SUBJECT: BE/180/16/PL - 1 No. dwelling. This application affects the setting of a Listed Building.

Land adj to 2, North Bersted Street, Bognor Regis, West Sussex, PO22 9AD

SITE PLAN
SCALE 1:200

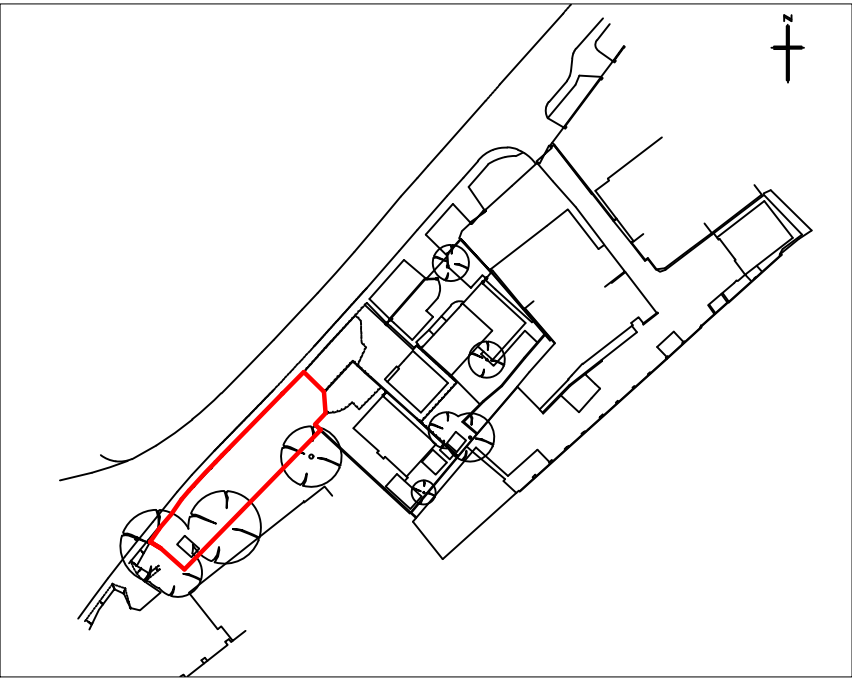
Two off street car parking spaces have been shown for the new dwelling; this meets with what the WSCC Car Parking Demand calculator would envision for a development of this scale and location. The cars used to demonstrate this appear to be smaller than average recommended (4.5 m by 2 m). However, it is clear that sufficient space for two parking bays each of 2.4 m by 4.8 m is available. Space to the rear of these for turning appears restrictive. The LHA require the applicant demonstrates turning on site so that a car can exit onto the highway in a forward gear. This should be shown via swept path analysis and also take in to account existing parking arrangements for no. 2. The parking spaces for no. 2 should be indicated on the plans also to ensure they don't conflict with access, turning and egress of vehicles from the new dwelling.

From an inspection of the plans and WSCC local mapping visibility to the north is sufficient. Visibility to the south could be improved by reducing the height of the boundary fence adjacent North Bersted Street. The applicant should consider this and is advised to amend the plans accordingly.

The area of new paving is within the extent of the highway boundary. The WSCC Local Area Engineer has indicated that a like for like material would be acceptable and this piece of land would remain highway.

The applicant should indicate parking arrangements for existing property and show via swept path analysis that vehicles associated with the new dwelling can turn on site to exit onto North Bersted Street in a forward gear. Please ask the applicant for this further information and re-consult.
